**Consultation Response from KC,  
Trees**

**2025/90013 Dewsbury and District Hospital, Halifax Rd, Dewsbury, WF13 4HS**

**Discharge of details reserved by conditions 5 (Arboricultural Method Statement) and 15 (bat/swift box) on previous permission 2023/91345 for erection of single storey building with roof top plant area to provide outpatient theatres, treatment rooms and consultant rooms with link to Boothroyd building, including demolition and remodelling of existing ramp and associated landscaping and drainage**

**Date Responded: 22.01.25**

Figure 1: Habitat Enhancement Plan

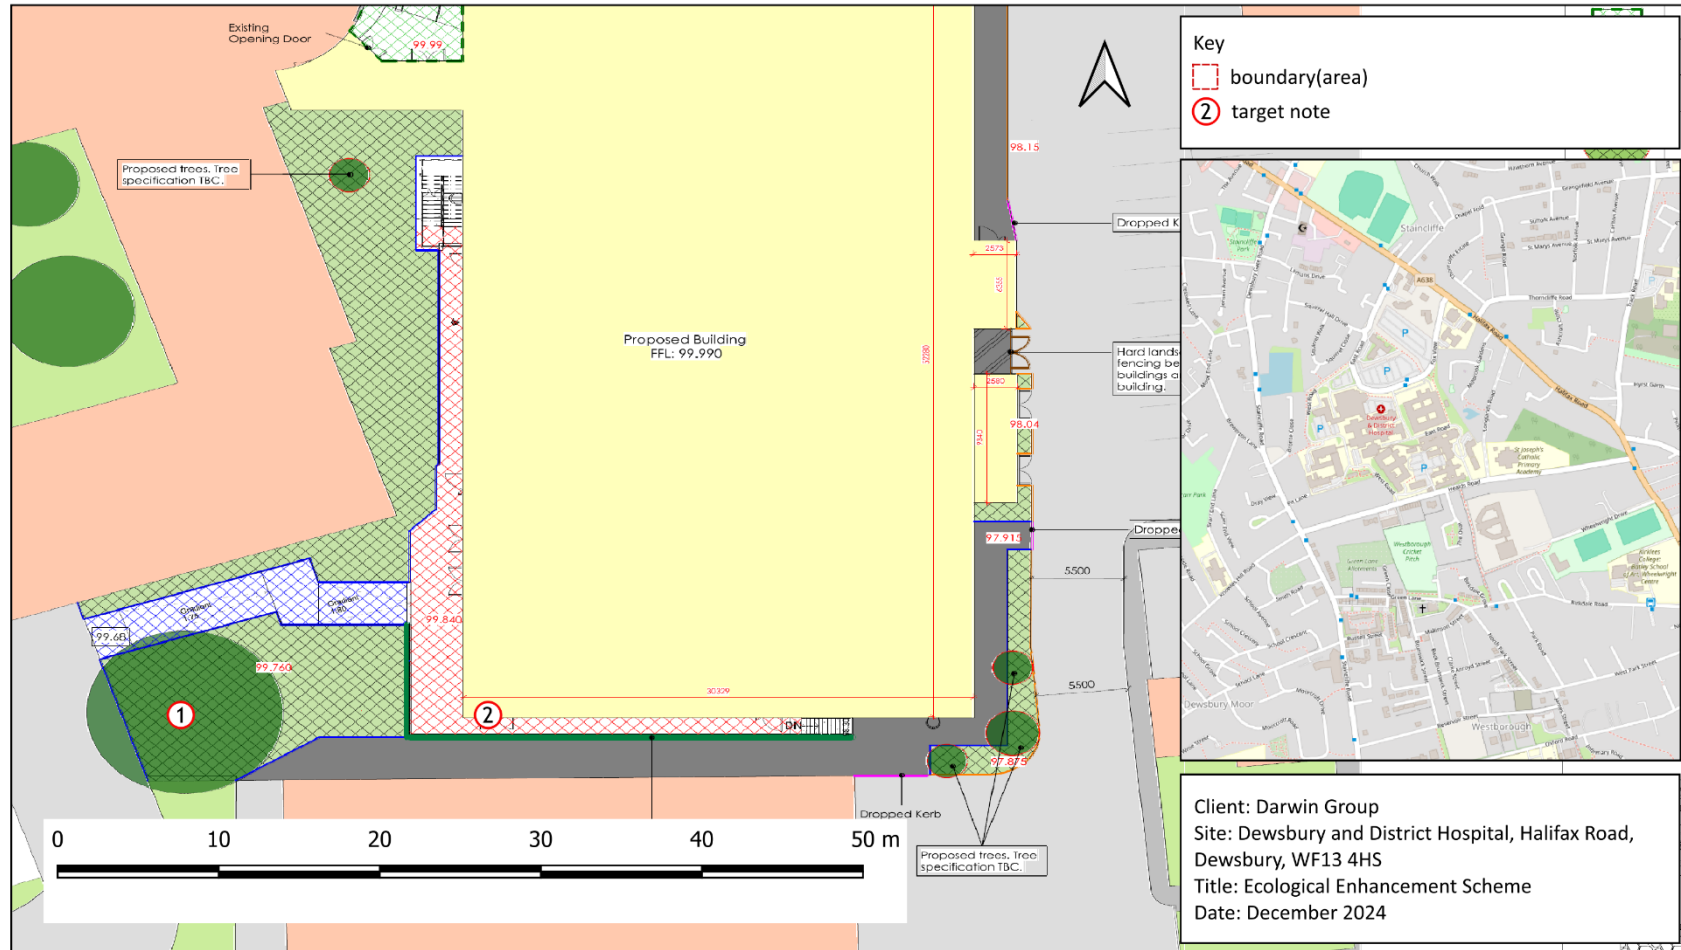
The Habitat Enhancement Plan shows that one new tree (species tbd) is proposed to be planted in the area of soft landscaping between the existing and proposed buildings. As this is a small area, it is recommended that an appropriate small, fastigate tree species is selected to avoid future conflicts with either building. In this case as there is limited space and limited light, I would suggest small, shade tolerant species such as rowan, whitebeam, hazel, cherry, or maple.

e.g. Flagpole cherry (*Prunus serrulata* 'Amanogawa'), Corkscrew Hazel (*Corylus avellana* 'Contorta') or snakebark maple (*Acer grosseri*).

These species offer good amenity value and have non-aggressive roots that would be unlikely to damage the foundations of the building.
